PLANNING CONSULTATION RESPONSE

Application No	2026/0014
Proposal	Unit 2, Park Springs, Spring Hill Road, Grimethorpe, Barnsley S72 7BQ
Address	Proposed steel containers to be converted into a private bar with car sales offices above (Retrospective)
Date of Consultation Reply	2 nd July 2026
Consultee	Highways DC

[2nd response]

SITE SURVEY
PARK SPRINGS
SPRINGHILL ROAD
GRIMETHORPE
S72 7BQ

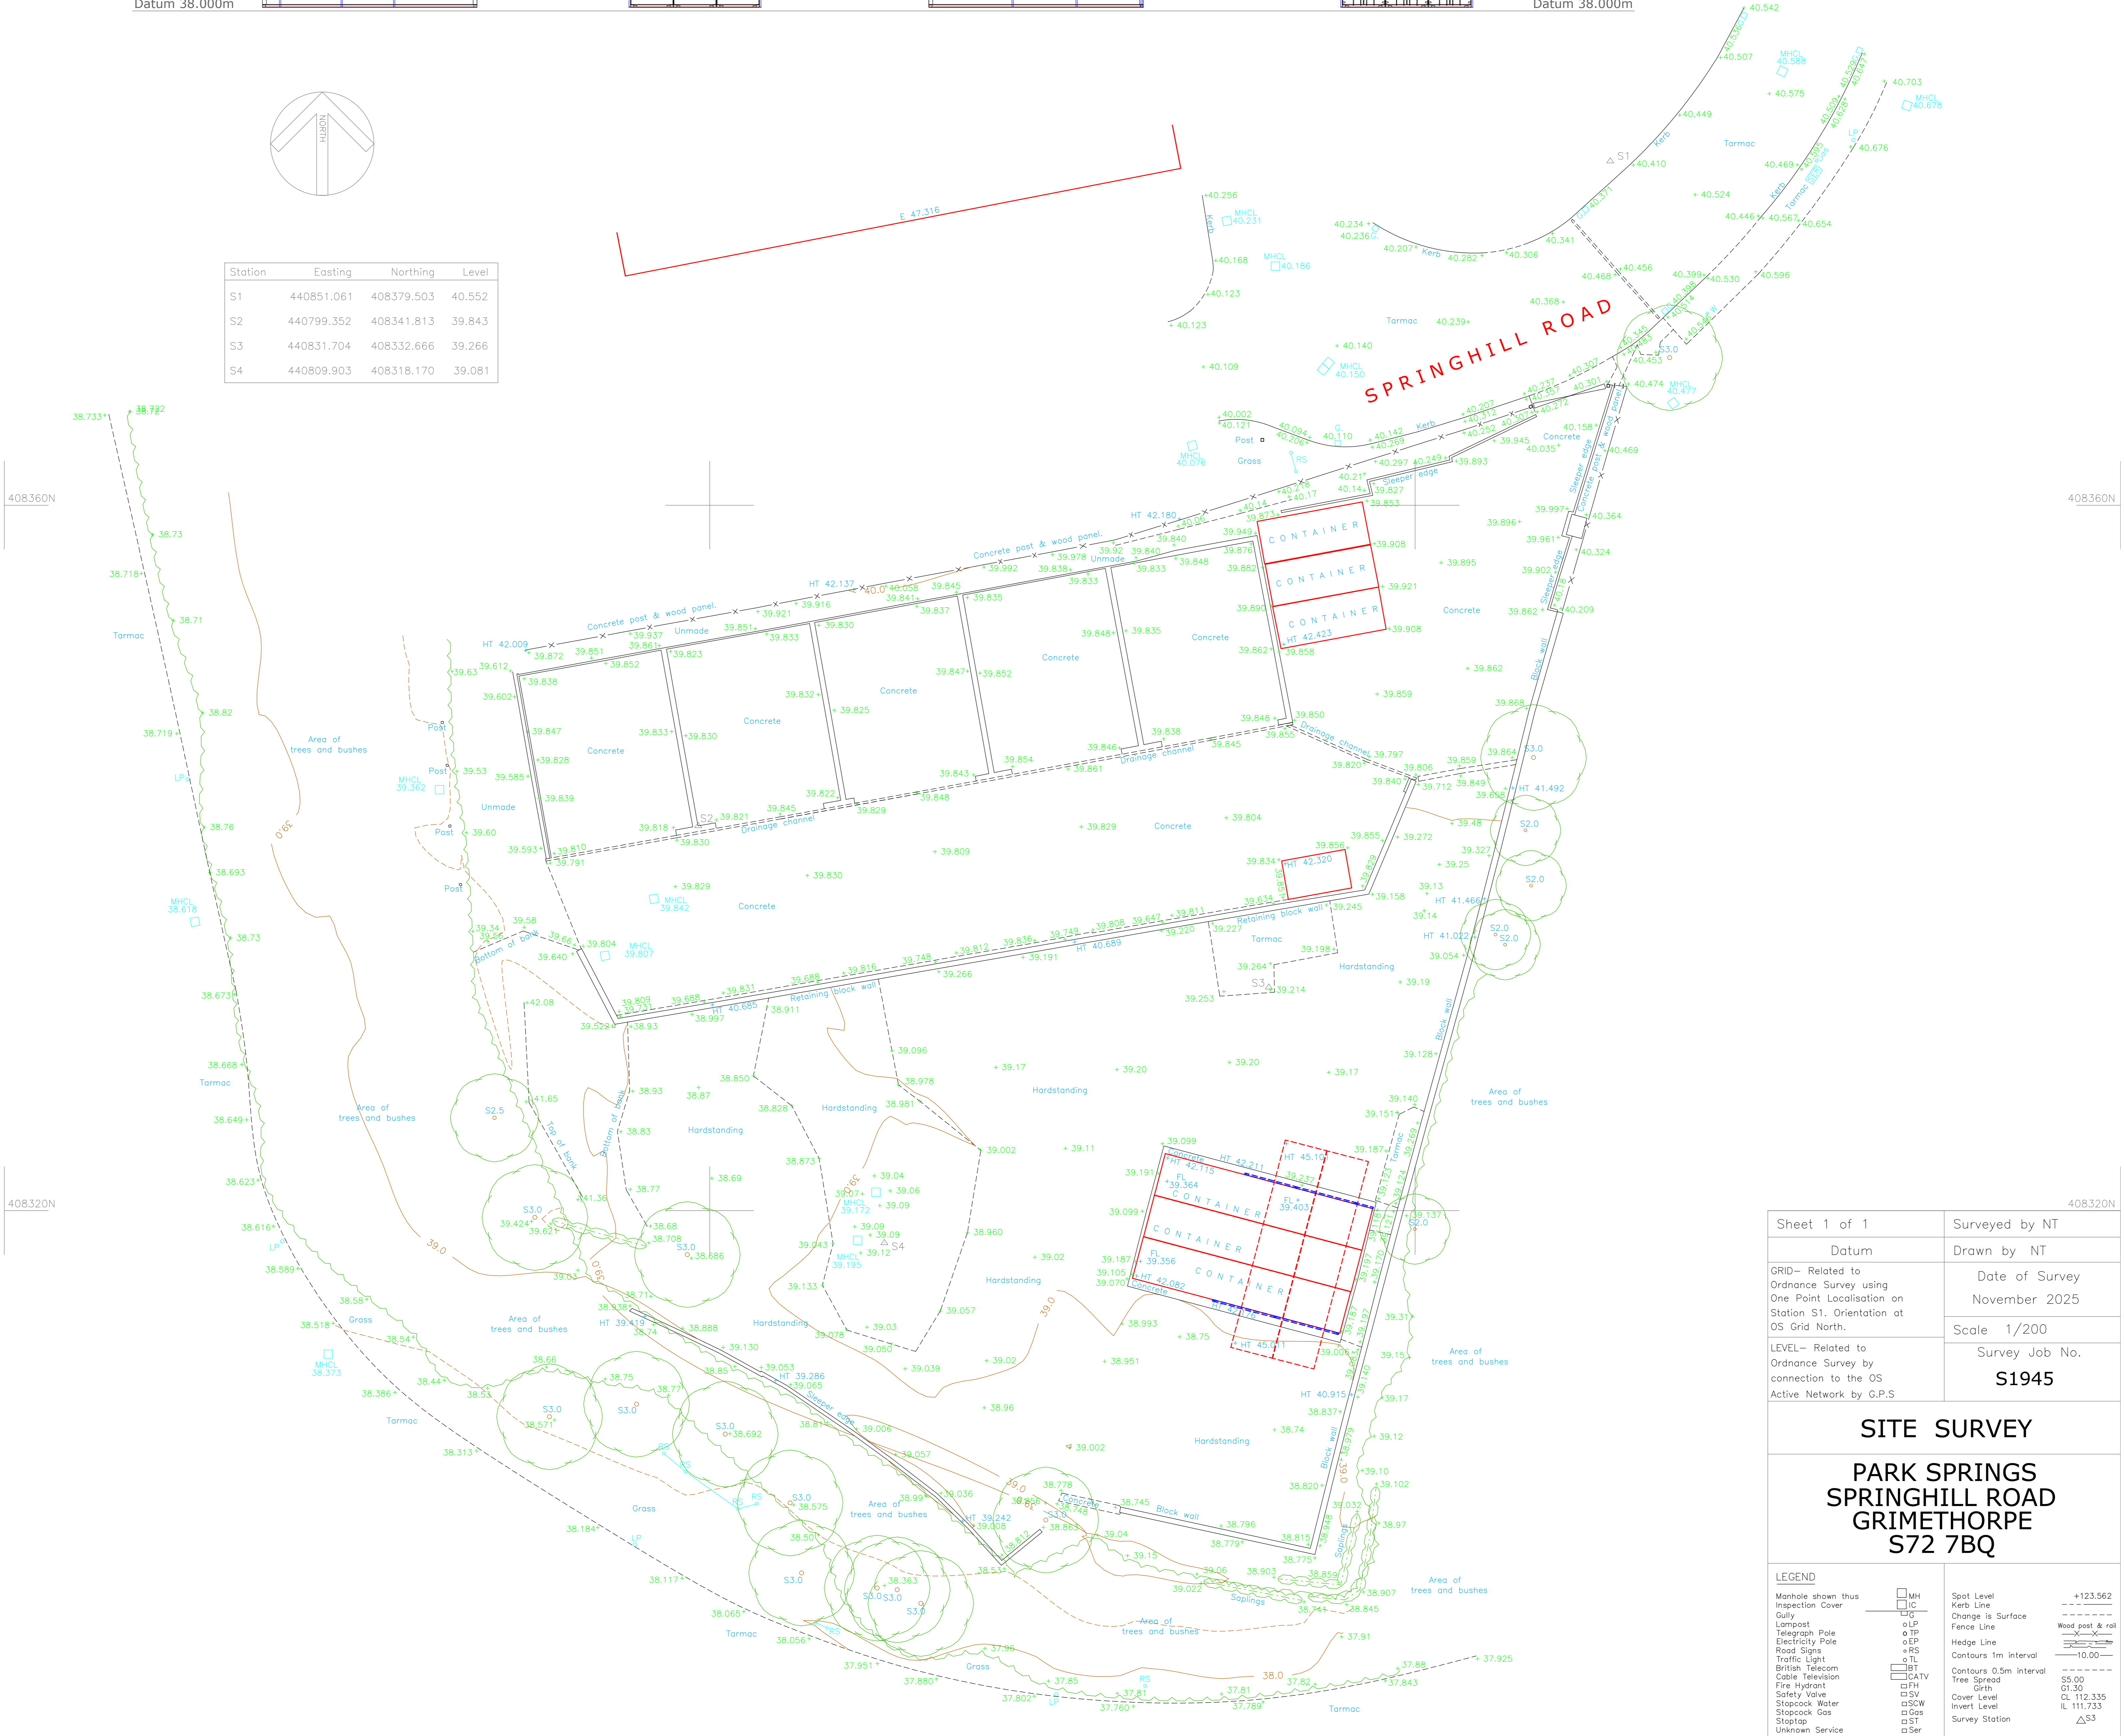
Furthermore, it is not known whether the site access is properly surfaced and drained; the submitted topographical survey indicates that the site access has a concrete surface but the standard of construction is unknown and no details have been provided regarding the means of drainage of the hard surfaced areas so as to prevent surface water discharging from the site onto the public highway.

It is also worth noting that the extent of the public highway ends approx. 4m to the east of the north-east corner of the site and that the red line boundary does not actually extend to the public highway.

2 SITE PLAN
1 : 500

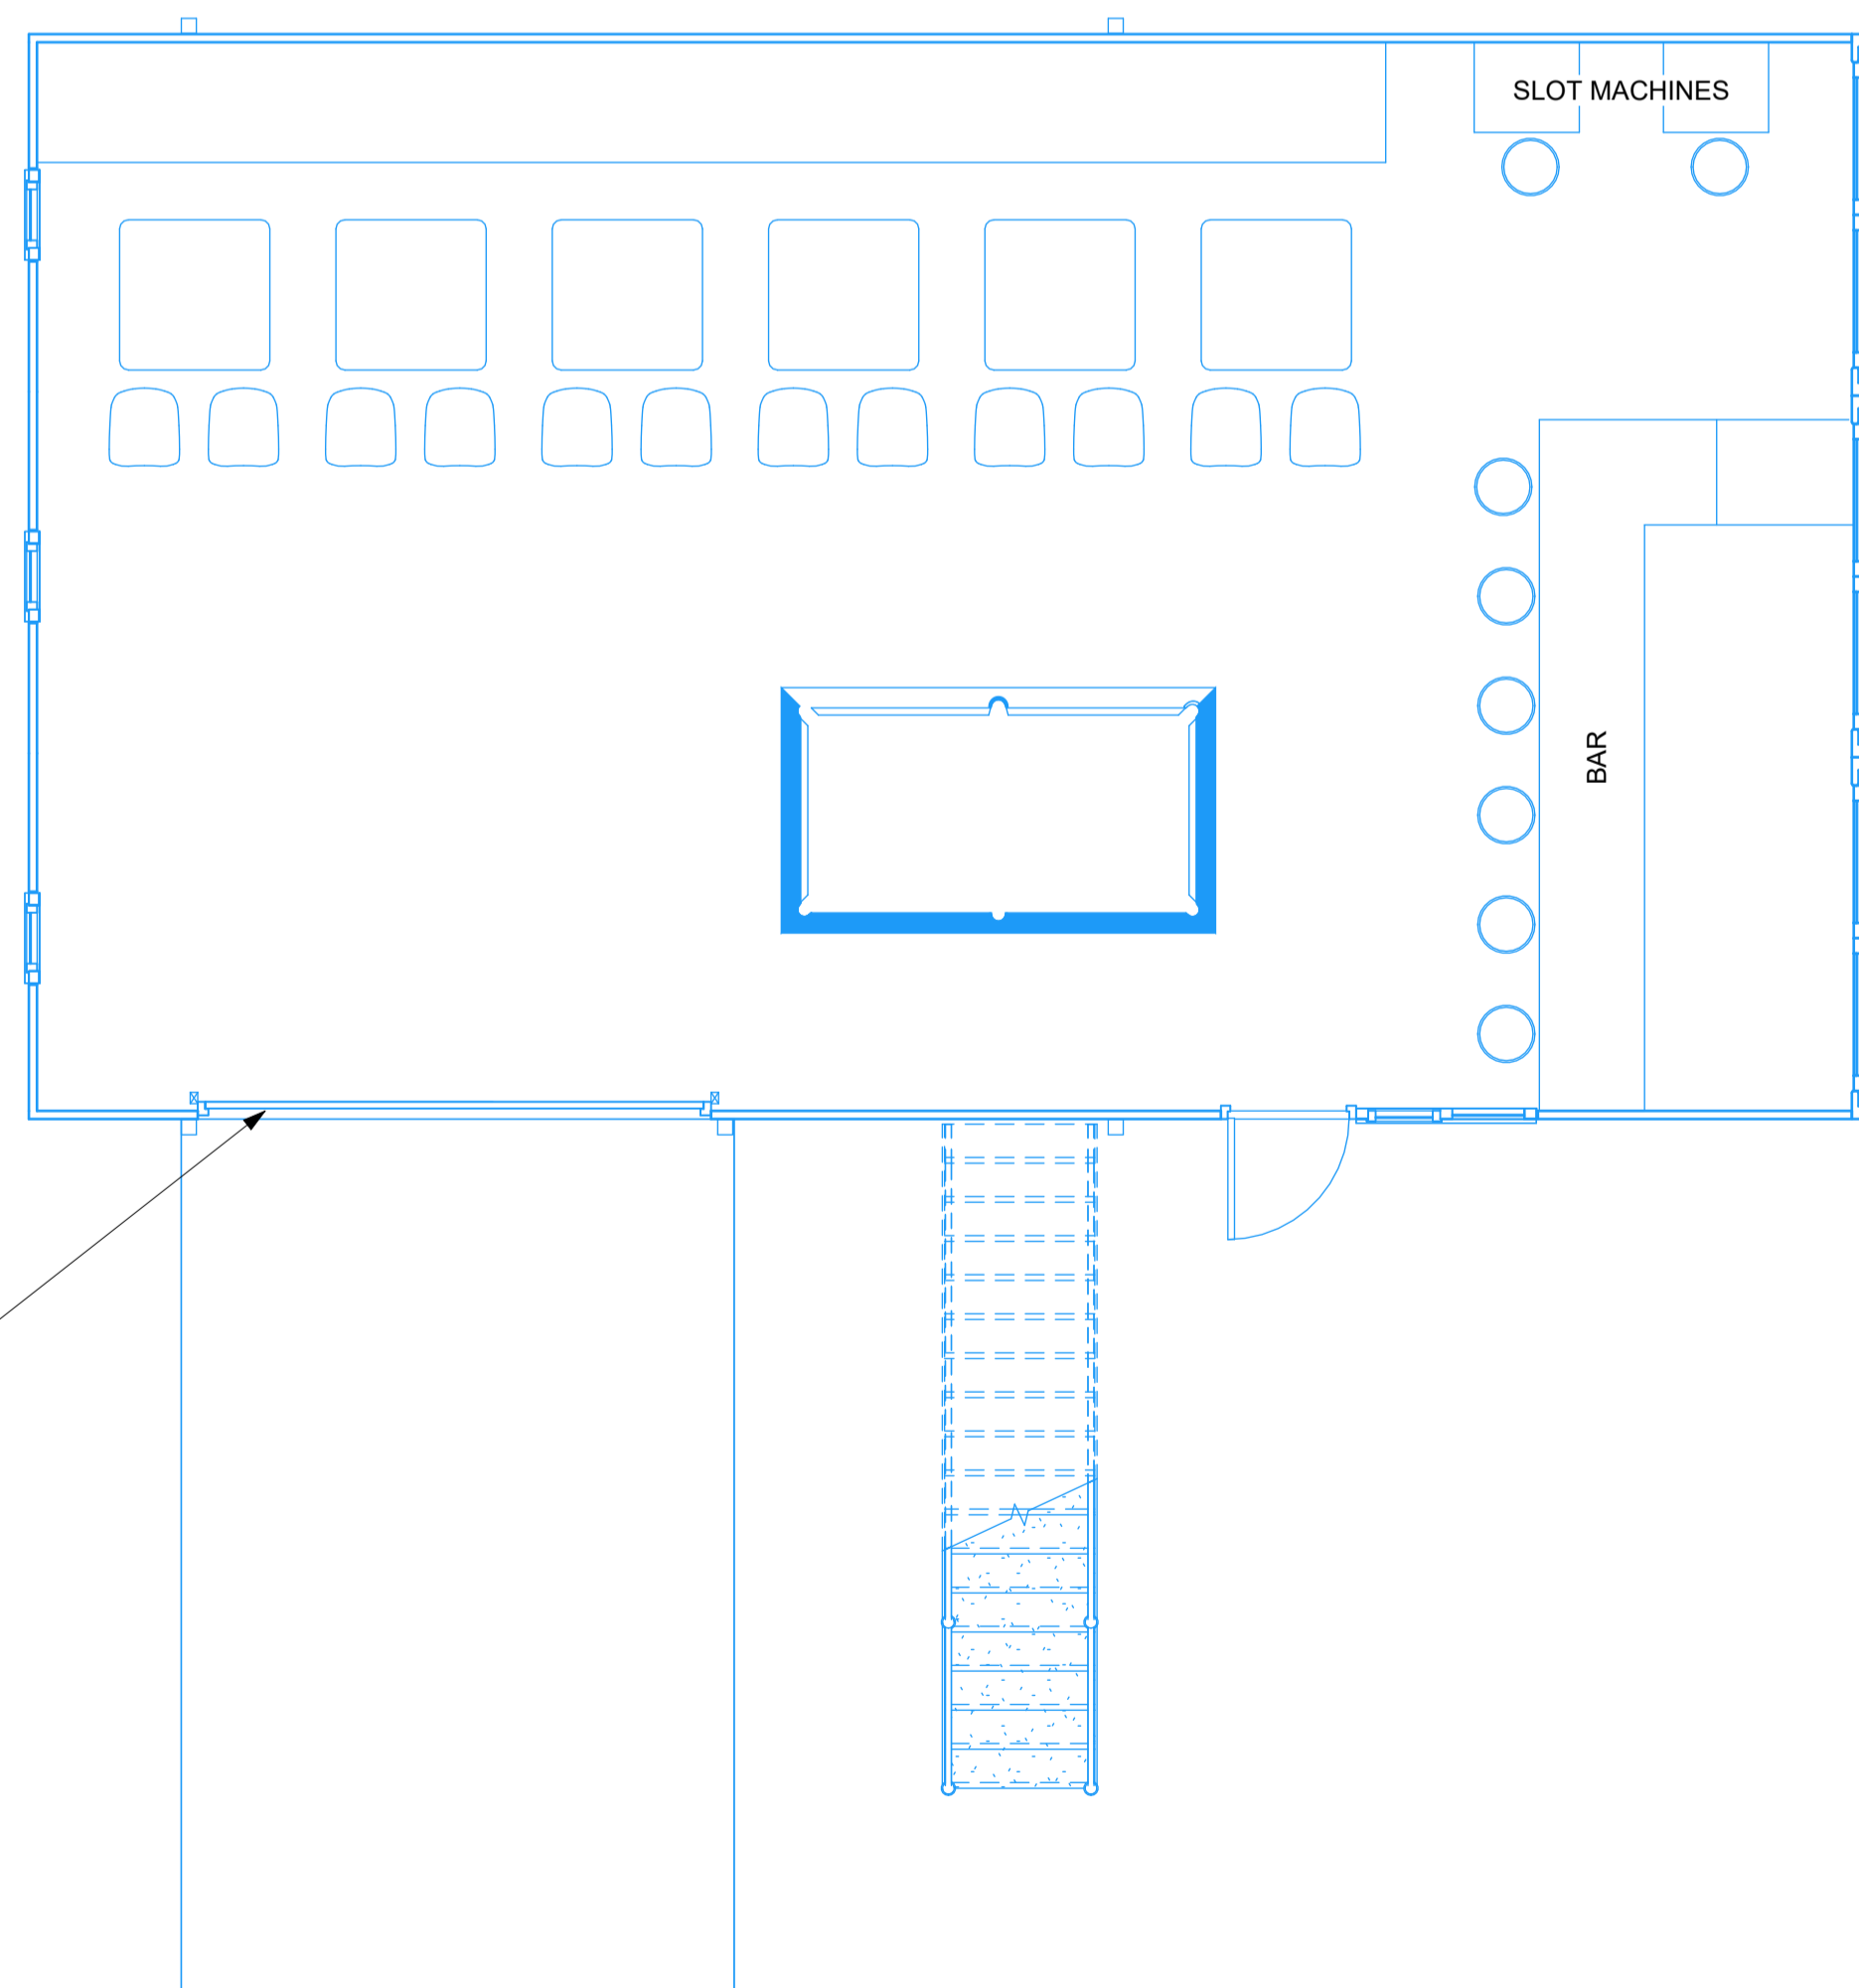
Within the submitted information, the existing use of the site is stated as being for the use of car sales. However, I am not aware of any planning permission having been granted for this use nor for the development of the site including the creation of a vehicular access.

No information has been provided regarding vehicular and pedestrian visibility from the new access. It would appear that the access is of sufficient width to allow the required 2m x 2m pedestrian visibility splays to be achieved and it would also appear that a sufficient sight line is achievable to the right for vehicles exiting the site due to the alignment of Spring Hill Road. However, the sight line to the left appears to be very substandard; it is acknowledged that vehicle movements approaching the site from the left (West) would likely be low speed and infrequent but notwithstanding this, the achievable sight line is still substandard. For example, for vehicle speeds as low as 10mph, the Manual for Streets document recommends a sight line of 2.4m x 11m; the site access can only achieve a sight line of approx. 2.4m x 3.2m which is well below the recommended distance.
